**Office of
Environment
& Heritage**

DOC18/679761

Exhibition of Nepean Hospital and Integrated Ambulatory Services Redevelopment (Stage 1) - 35-65 Derby Street, Kingswood (SSD 8766)

Attachment 1: OEH Comments - Exhibition of Nepean Hospital and Integrated Ambulatory Services Redevelopment (Stage 1) - 35-65 Derby Street, Kingswood (SSD 8766)

- EXISTING TREES TO BE RETAINED
- EXISTING TREES TO BE REMOVED
- PROPOSED TREE PLANTING
- PROPOSED GROUND COVER PLANTING

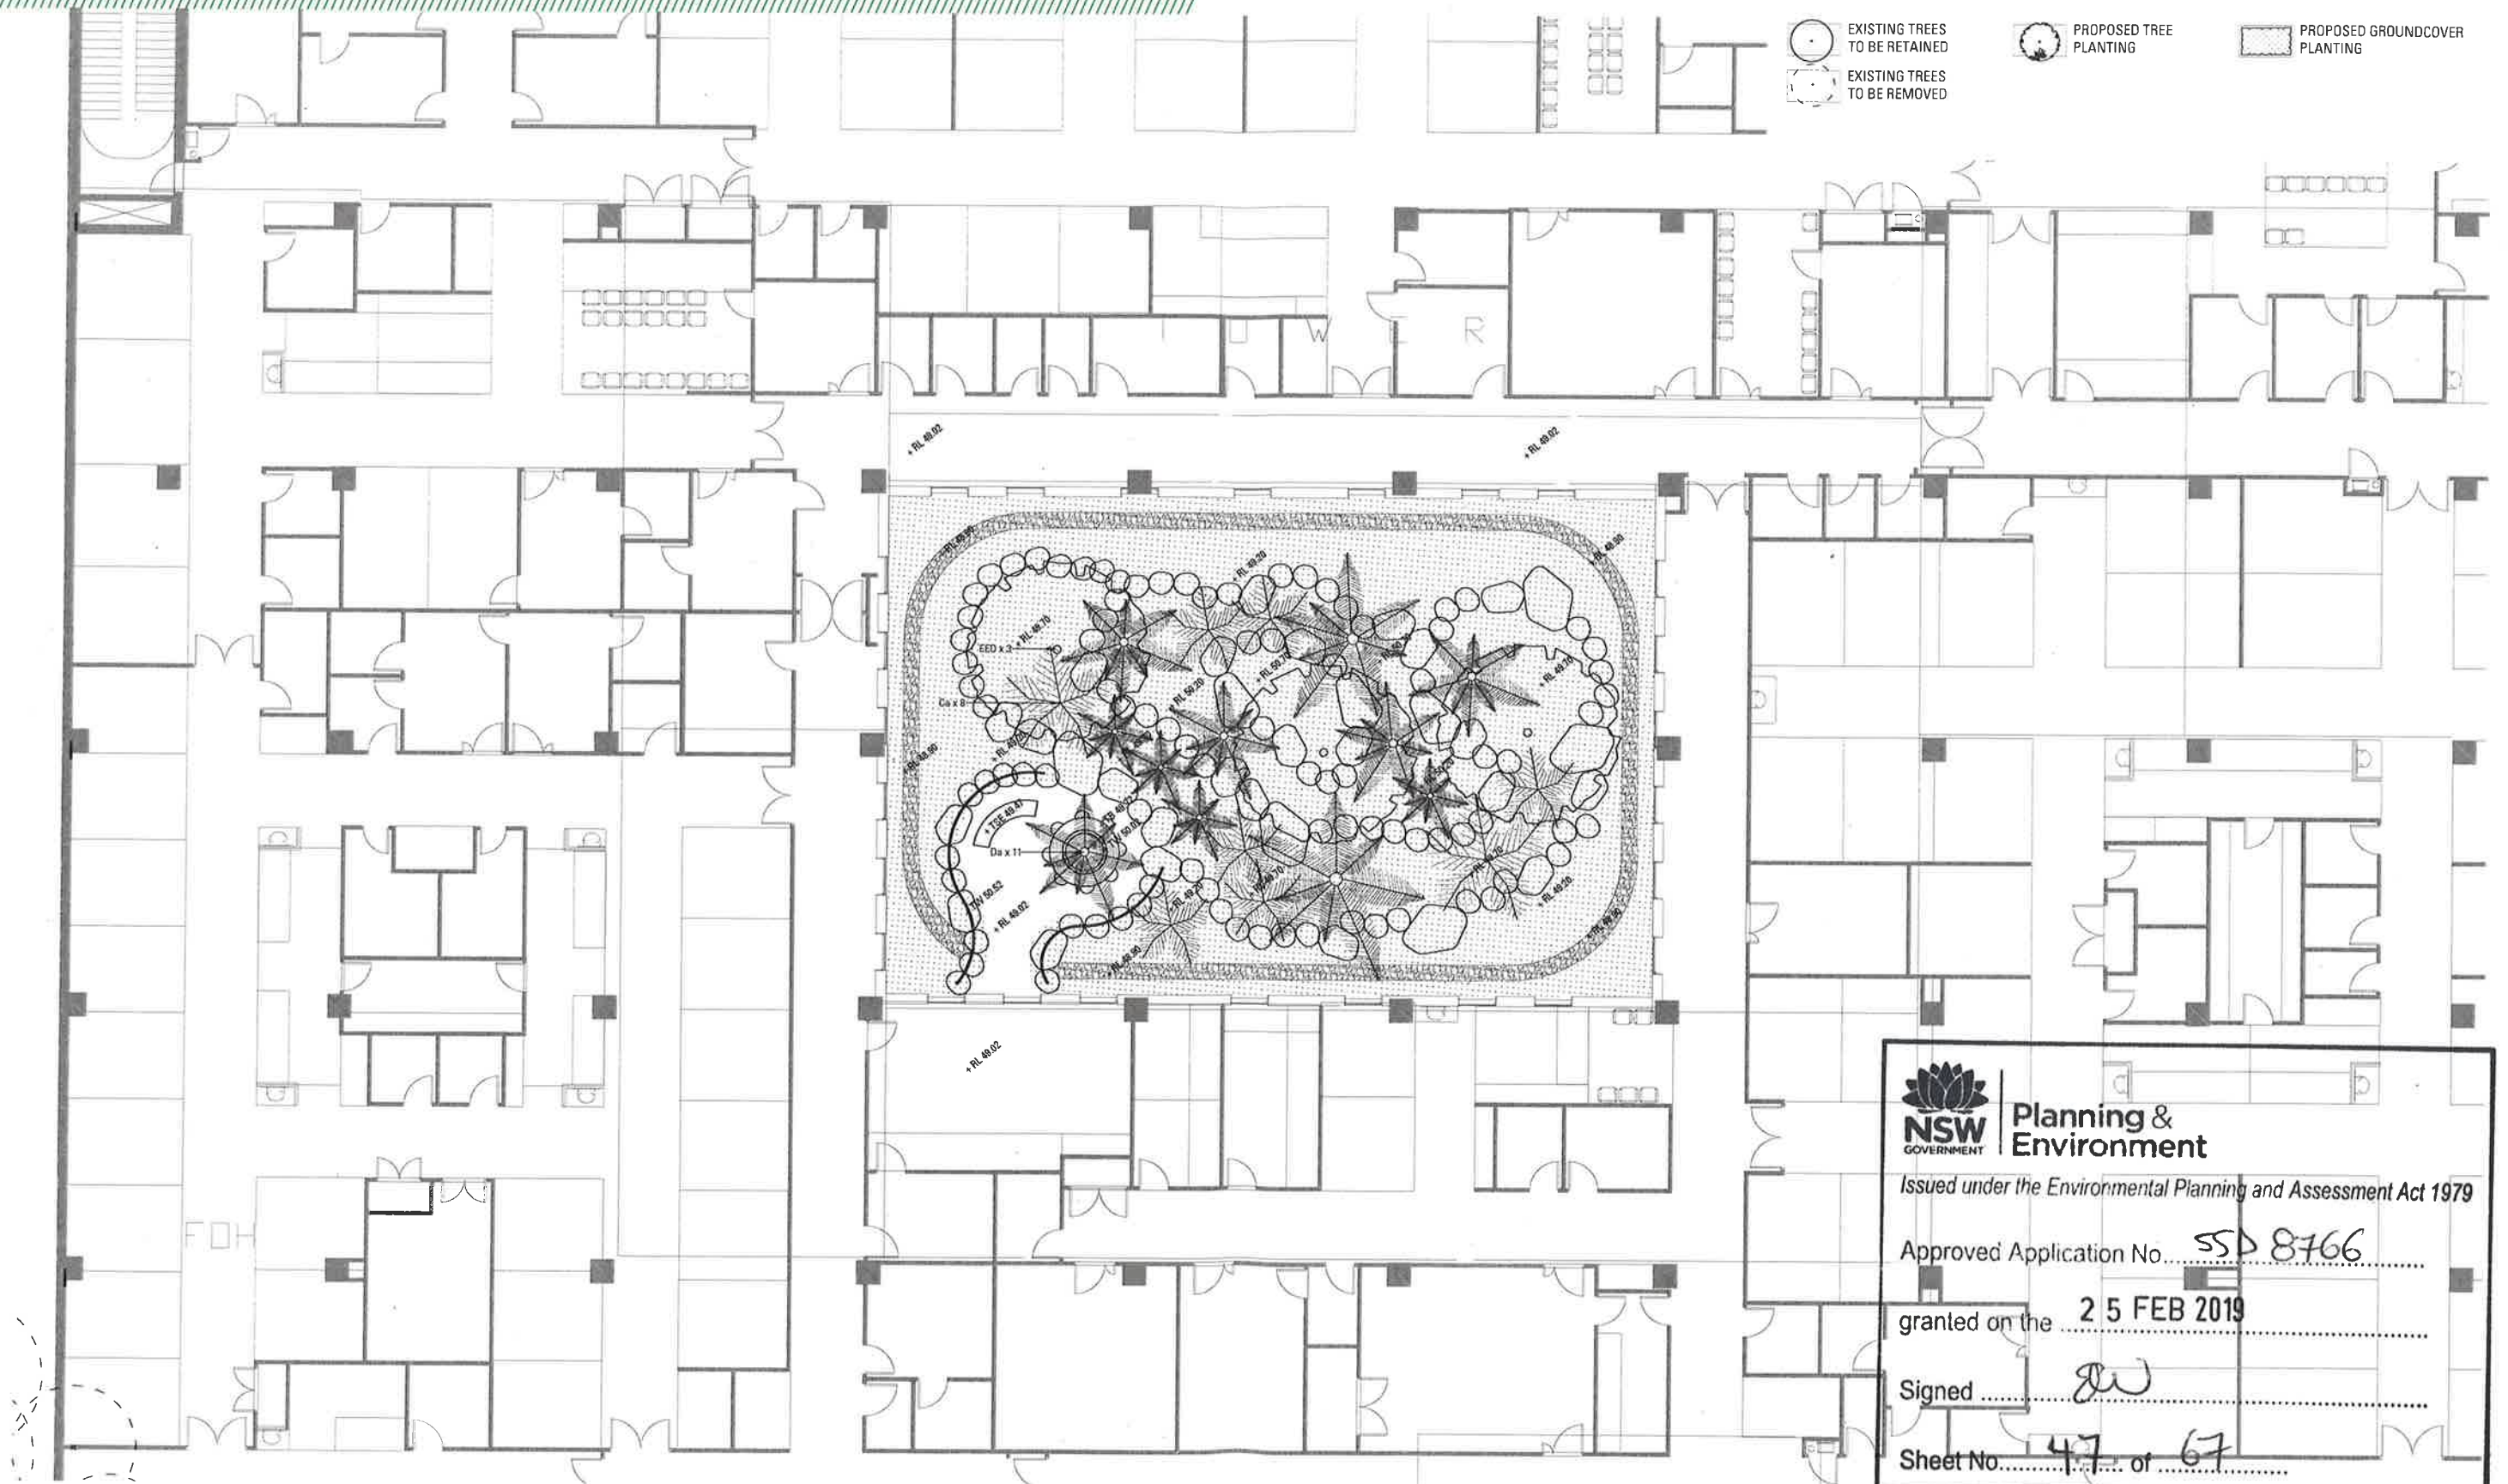
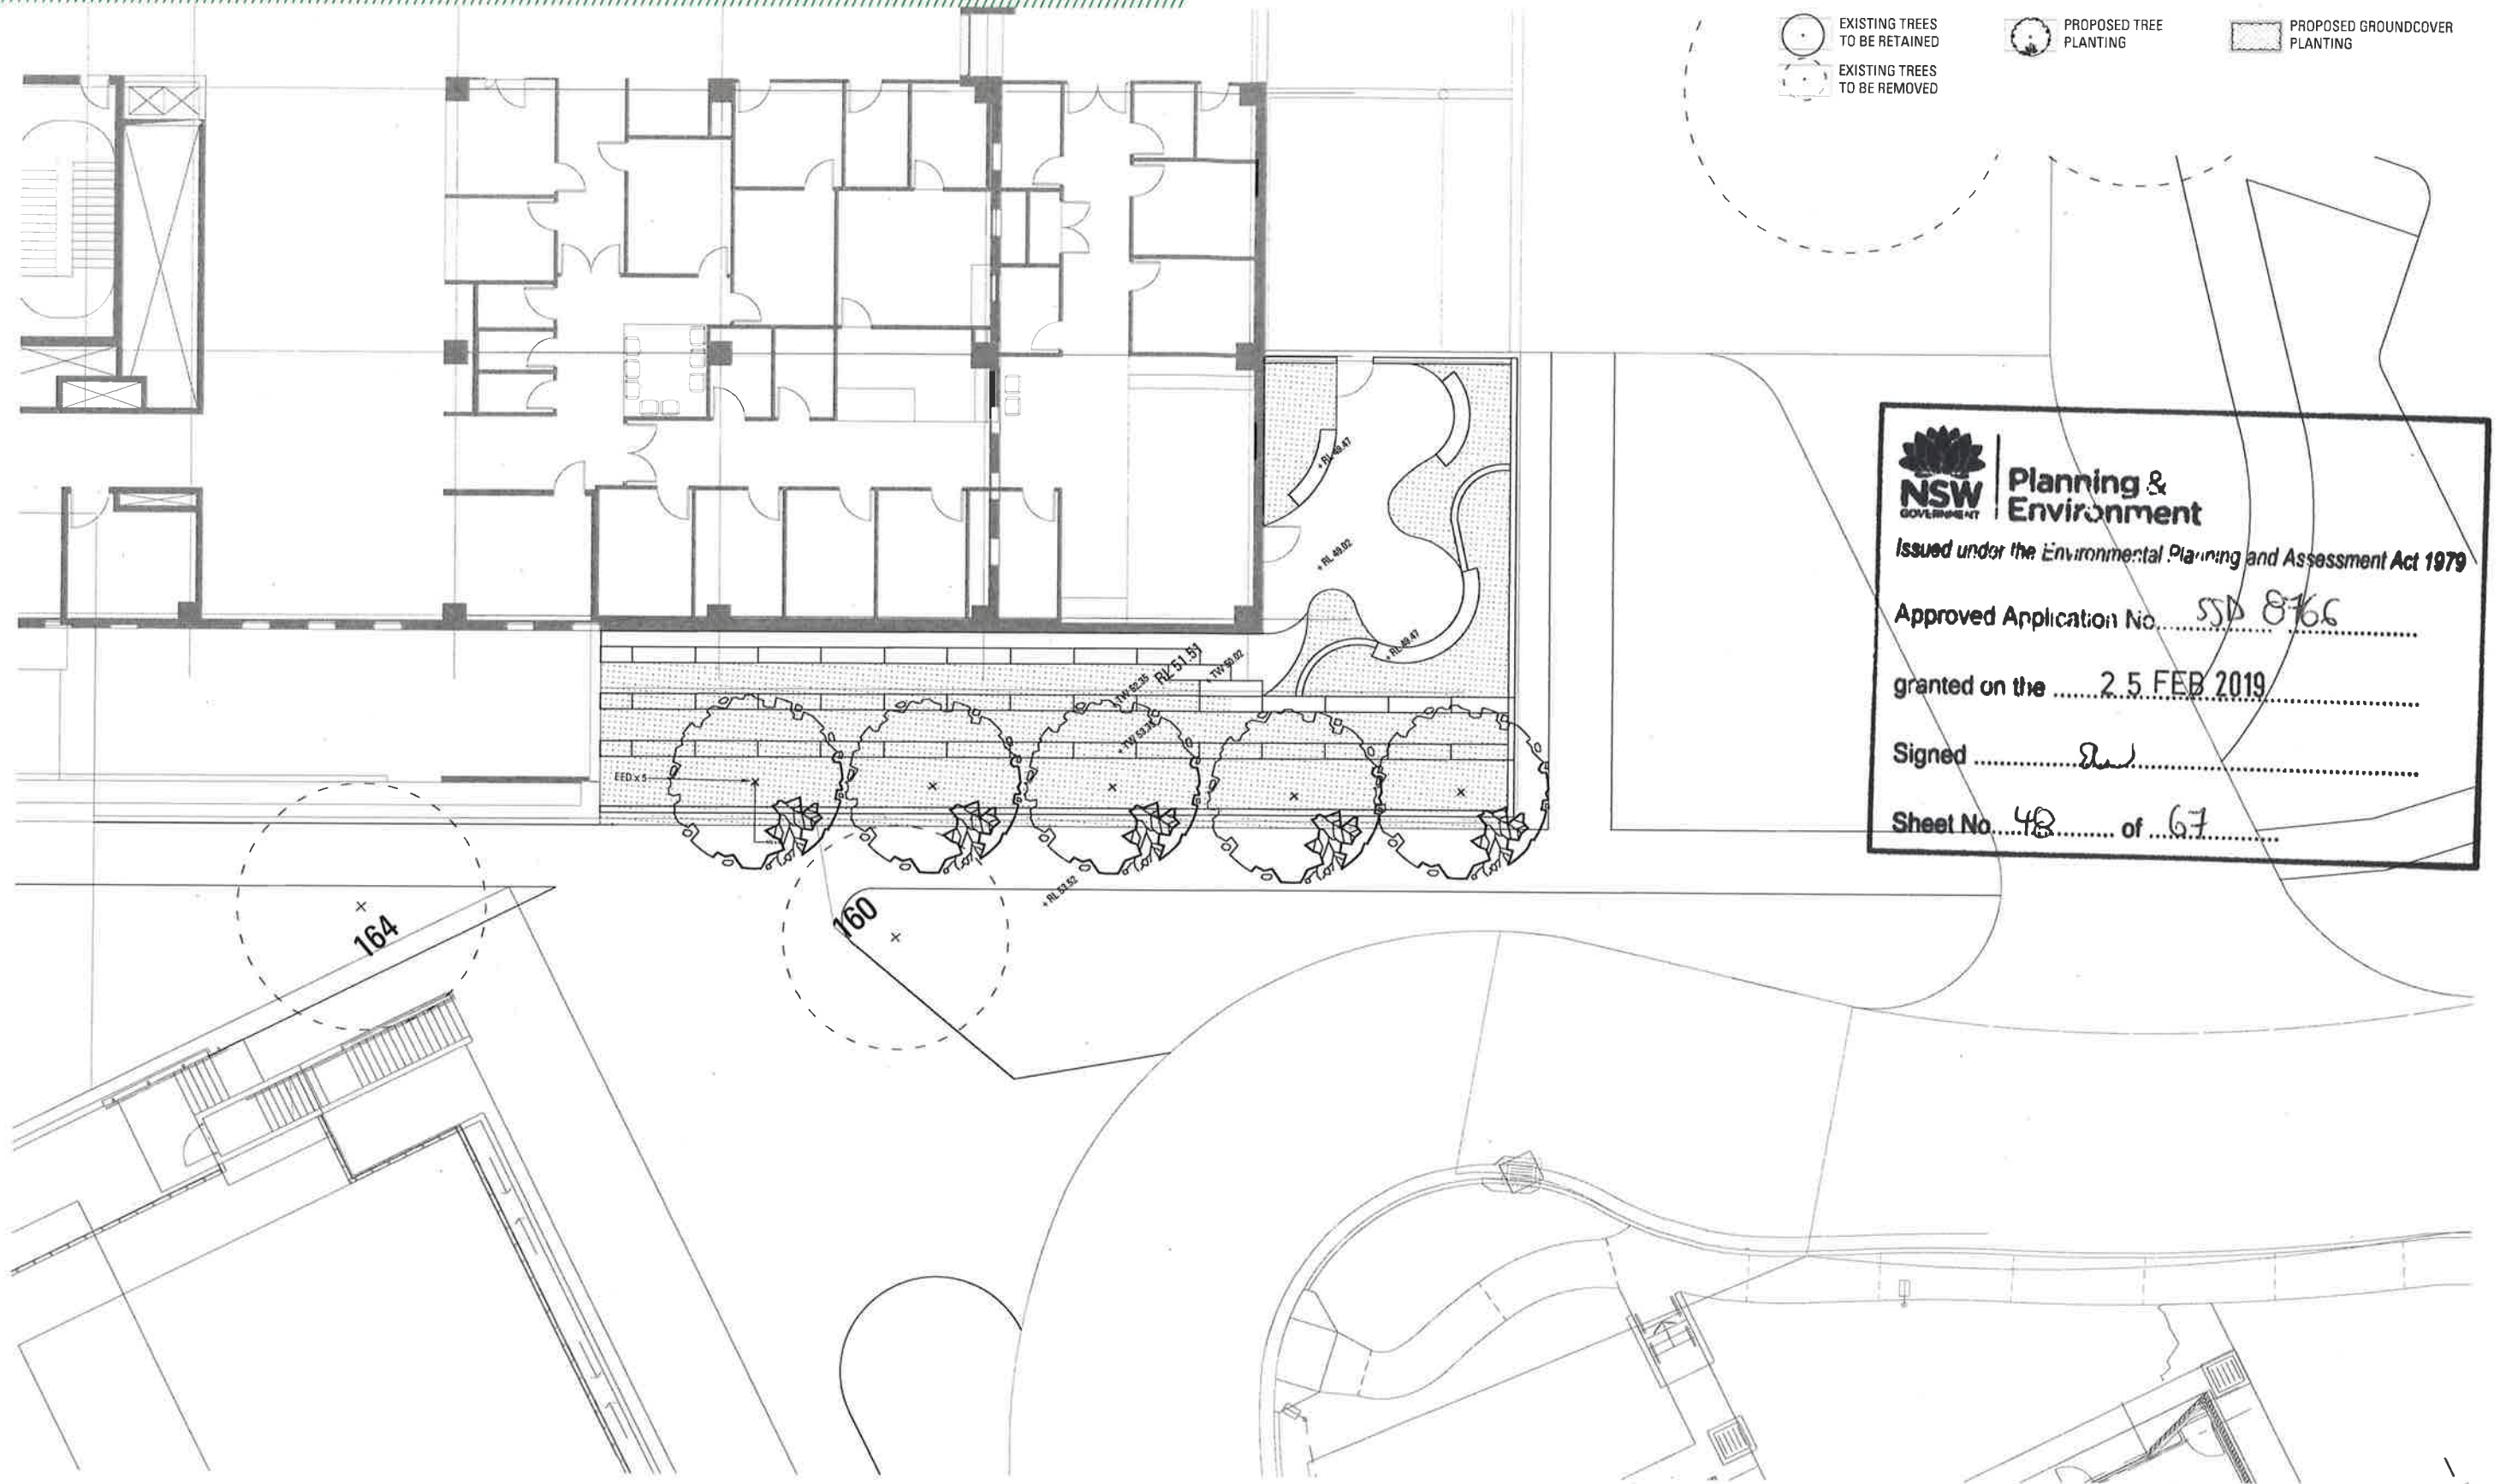
1. Clarification is required on which trees are to be retained and removed and this is to be shown on one map, as the proposal is currently unclear in this regard. The Biodiversity Development Assessment Report (BDAR) needs to be consistent with the Arboricultural Development Assessment Report. The information in the BDAR is confusing, for example it includes the following "The locations of trees in Figure 8 do not align with the location of trees in Figure 11. It is assumed that Figure 8 in general provides a more accurate location of trees on part of the site. These two figures (Figure 11 and Figure 8) are an attempt to try to reconcile the two different tree plans" (page 76).

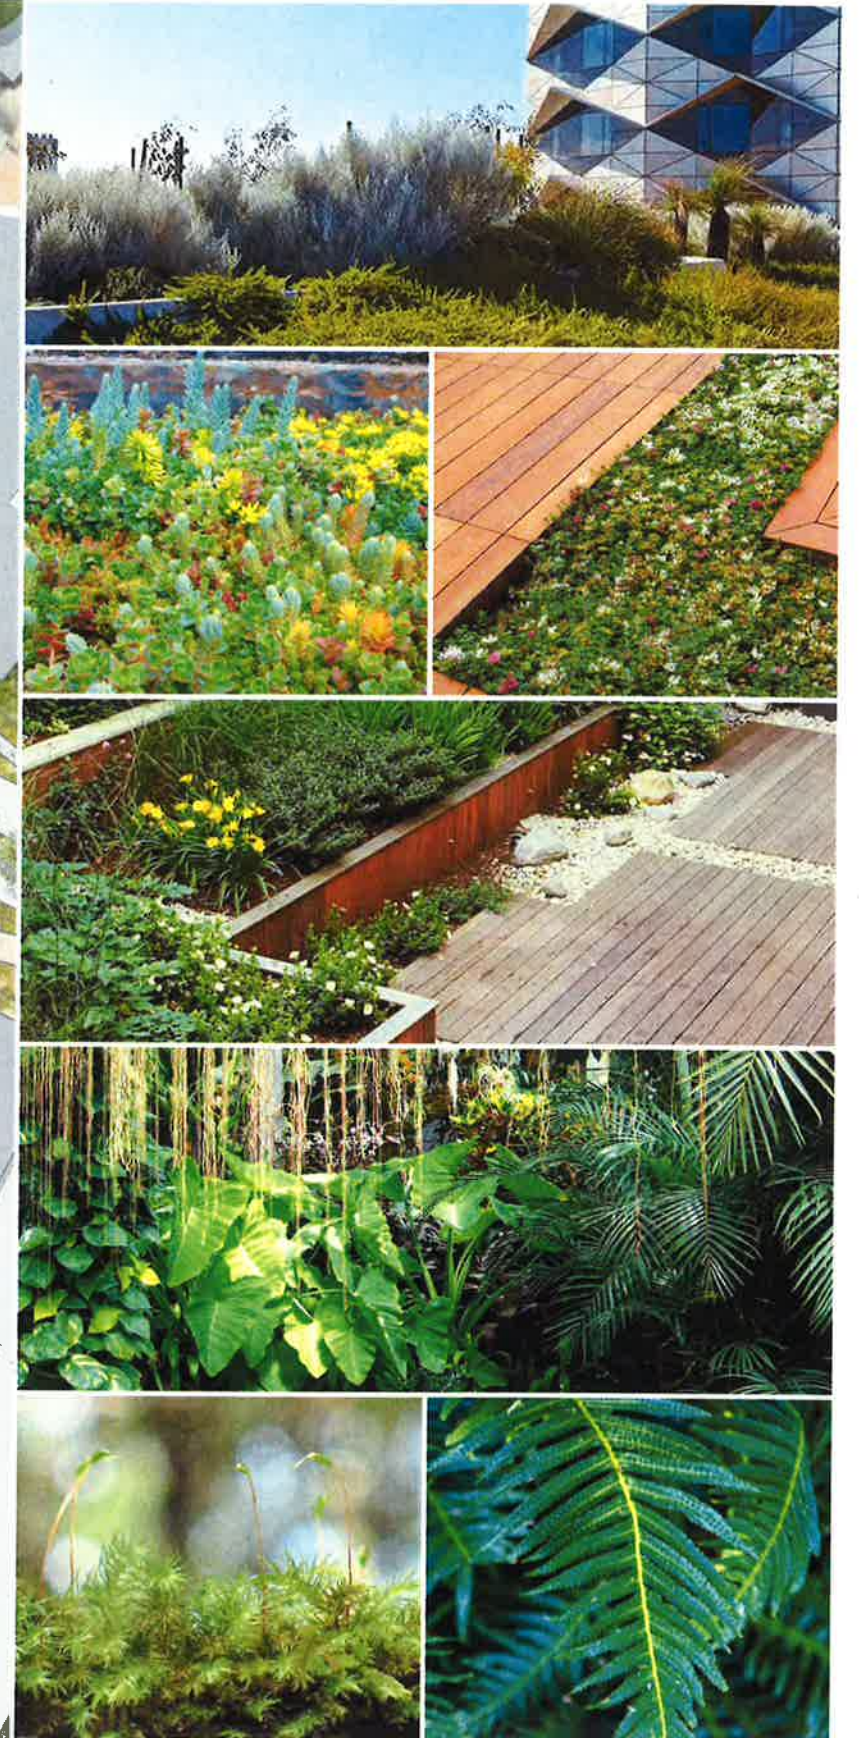
<http://climatechange.environment.nsw.gov.au/Adapting-to-climate-change/Green-Cover>. While, the rooftop landscape plan shows a 'sedum green roof' on Level 9, local natives should be used preferably, and the uppermost roof level presents a good opportunity for an additional green roof.
